From: Amanda Scholes on behalf of Planning.Responses
Sent: 21 December 2020 12:17
To: Planning Scanning
Subject: FW: Planning Consultation on: BN/151/20/PL

App No: BN/151/20/PL
Address: Land at rear of Poachers Eastergate Lane Eastergate PO20 3SJ
Proposal: Erection of 1 No. 4 bedroom detached dwelling with detached carport (resubmission following BN/46/20/PL). This site is in CIL Zone 3 & is CIL Liable as new dwelling & is a Departure from the Development Plan.

20-038/2A

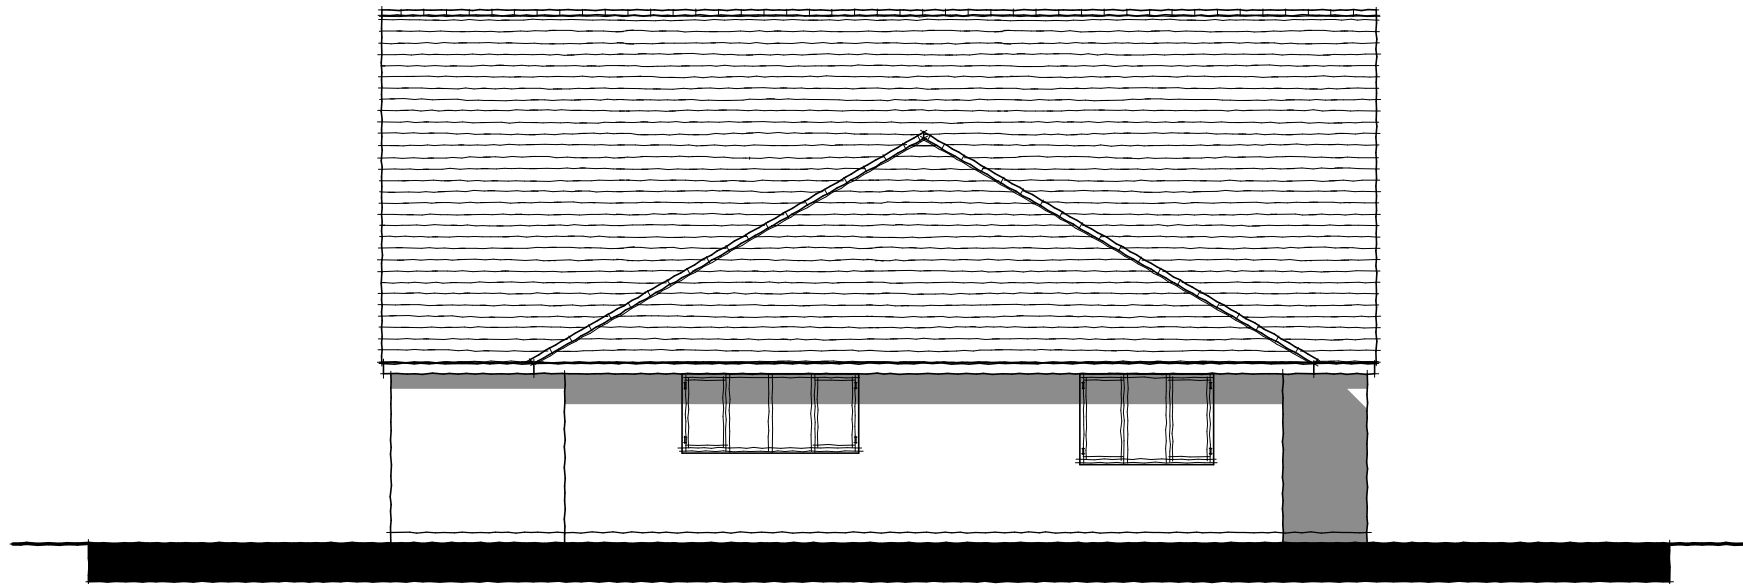
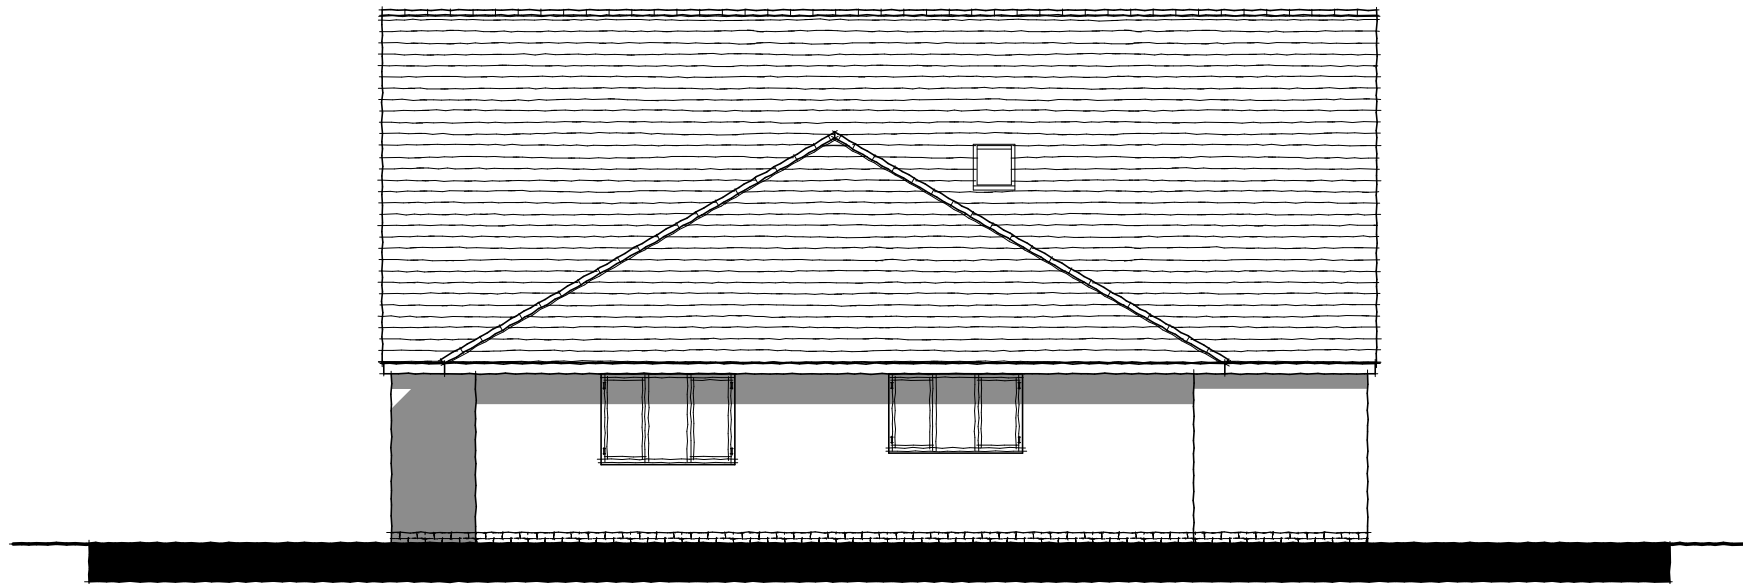
We require that a bat brick is integrated into the building onsite facing south/south westerly positioned 3-5m above ground.

We would like a bird box to be installed on the building and / or tree within the garden of the property.

PROPOSED SITE PLAN

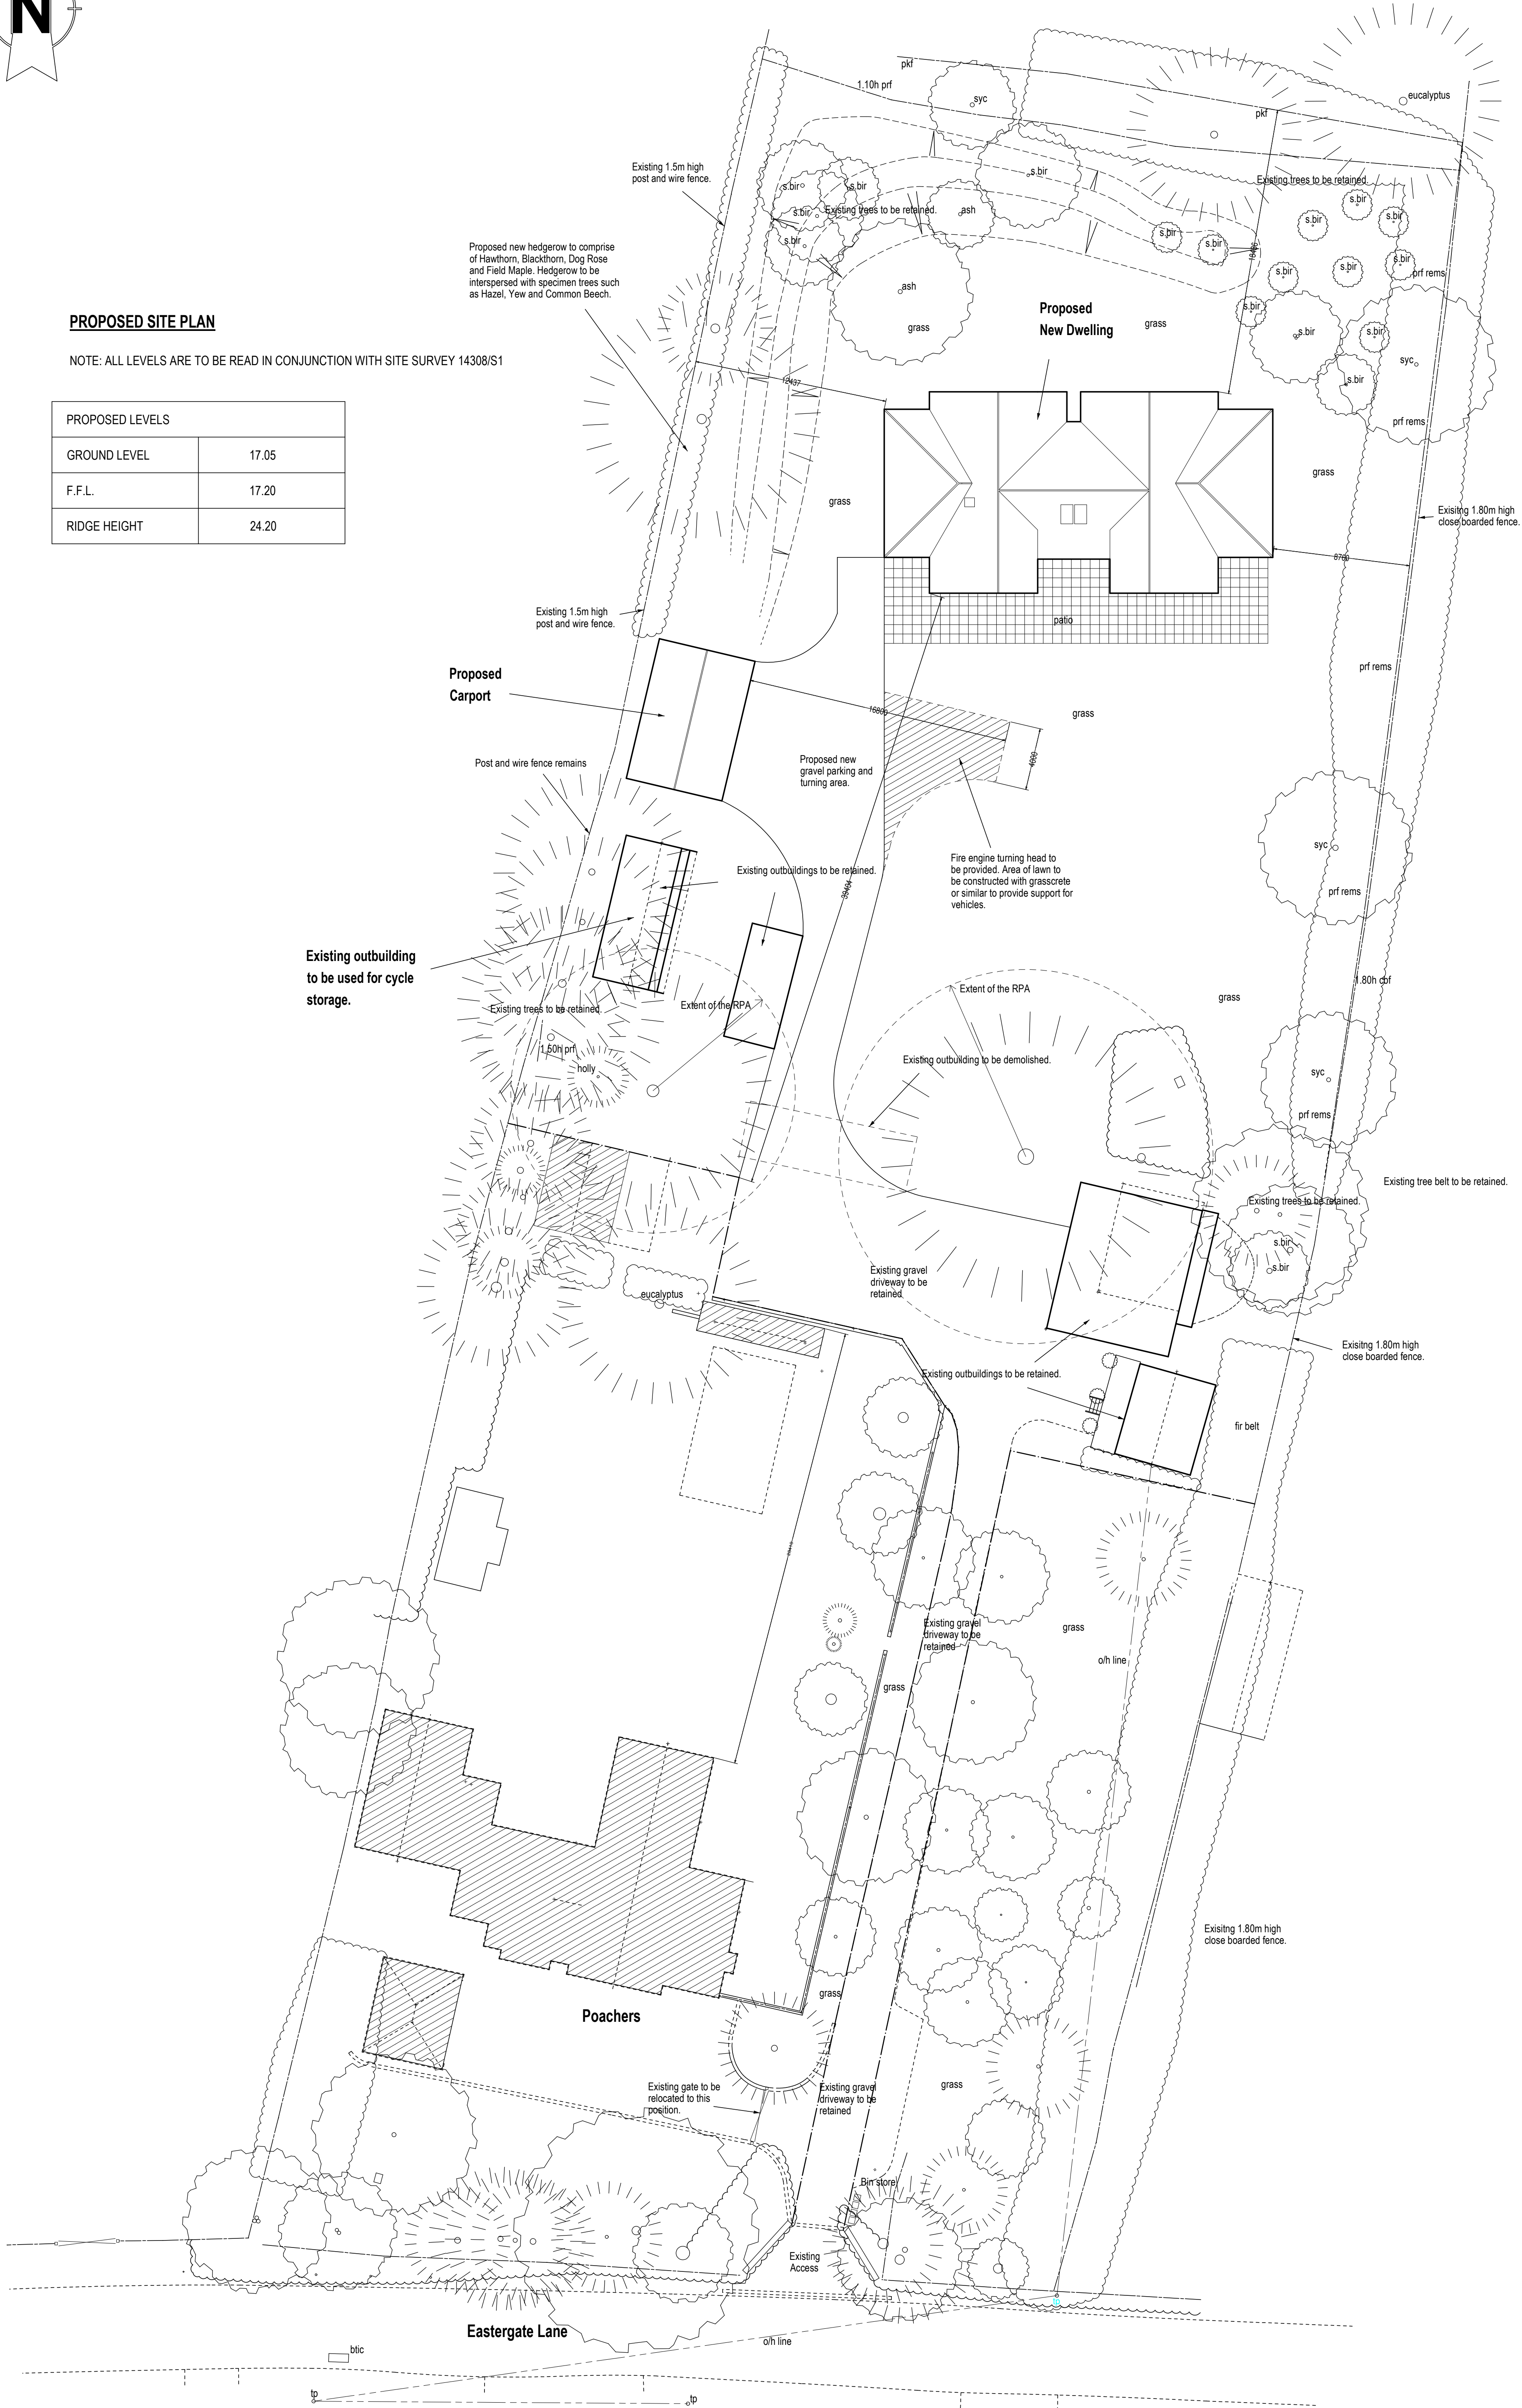
The hedgerows on site are used by bats for commuting and foraging and will need to be retained and enhanced for bats. This will include having a buffer strip around the hedgerows and during construction fencing should be used to ensure this area is undisturbed. Any gaps should also be filled in using native hedge species to improve connectivity. Conditions should be used to ensure this.
